Our ref: OUT22/6268

Subject: Albion Park Quarry **Stage 7 (SSD-10369) Environmental Impact Statement (EIS)**

Detailed advice to DPE Planning & Assessment regarding the Albion Park Quarry Project Stage 7 (SSD-10369) Environmental Impact Statement (EIS)

Figure 10 – Stream order in and around the current extraction area and proposed Stage 7.

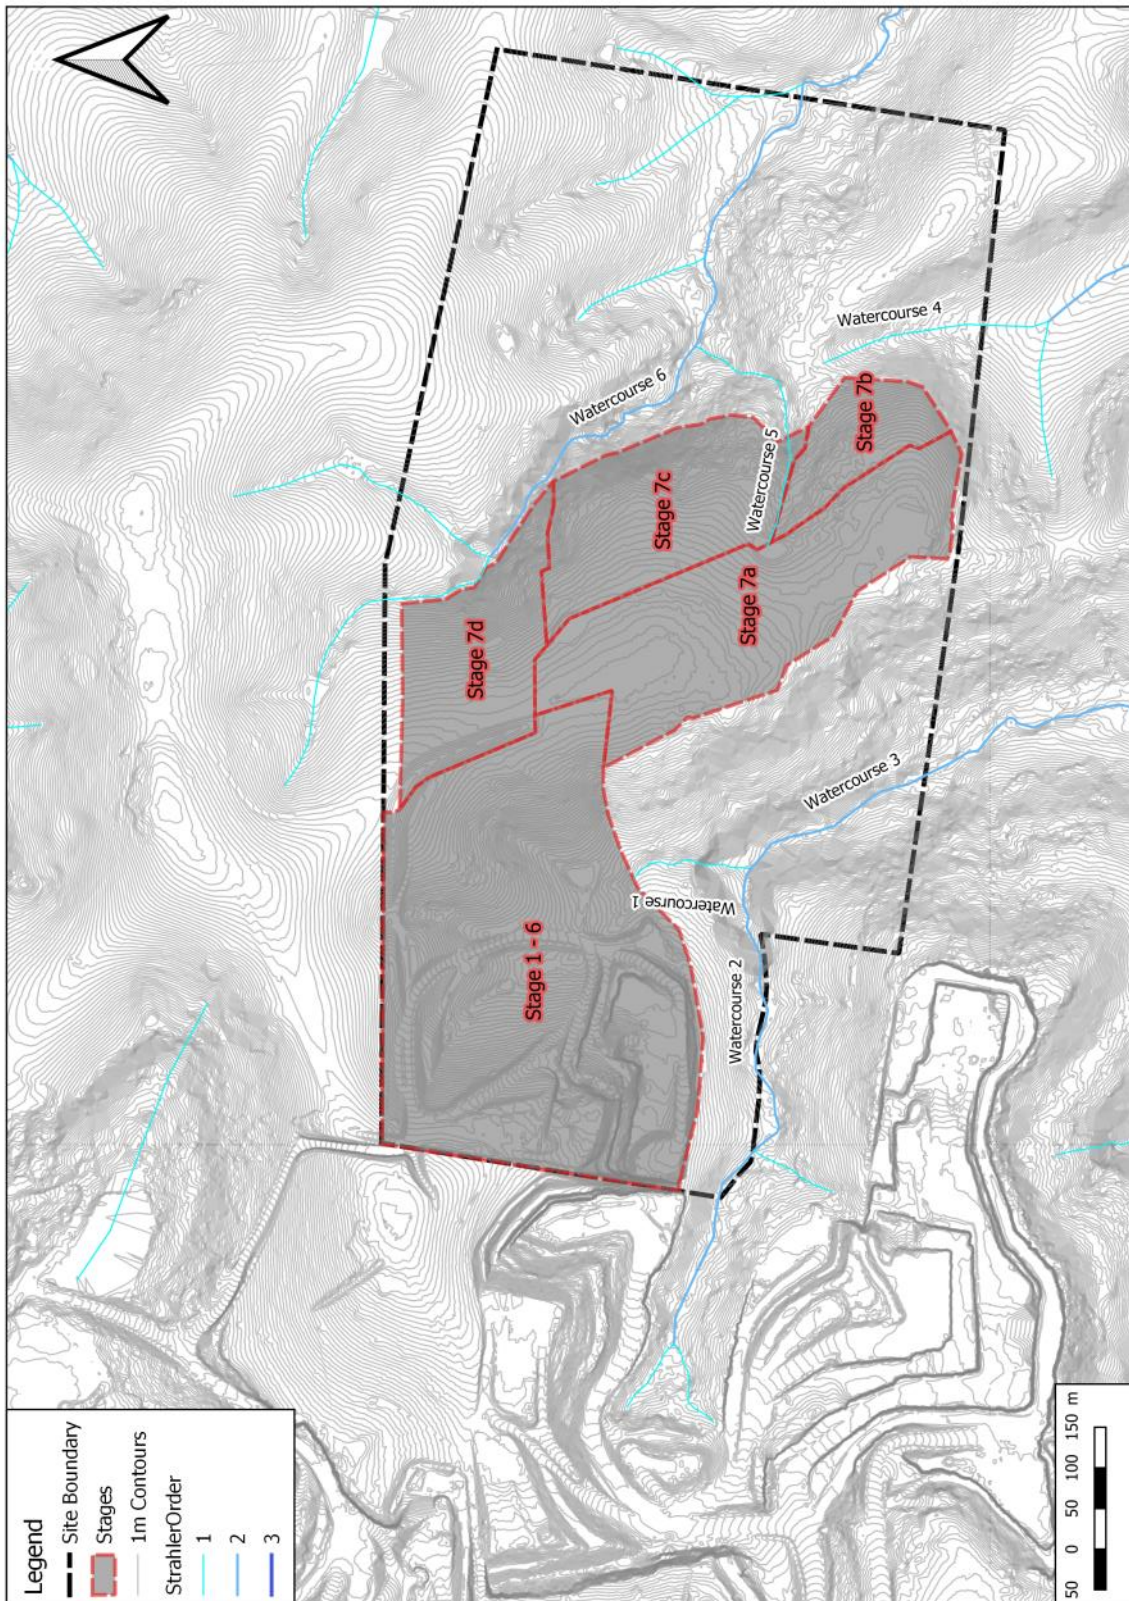
Works are proposed within waterfront land of a second order watercourse on Lot 3709. These works need to be considered for setback requirements in accordance with the Guidelines for Controlled Activities on Waterfront Land. A 20m setback measure from top of bank should be provided for each side of the watercourse.

- A review is requested of the works on waterfront land to show due consideration to the setback requirements in the Guidelines for Controlled Activities on Waterfront Land.
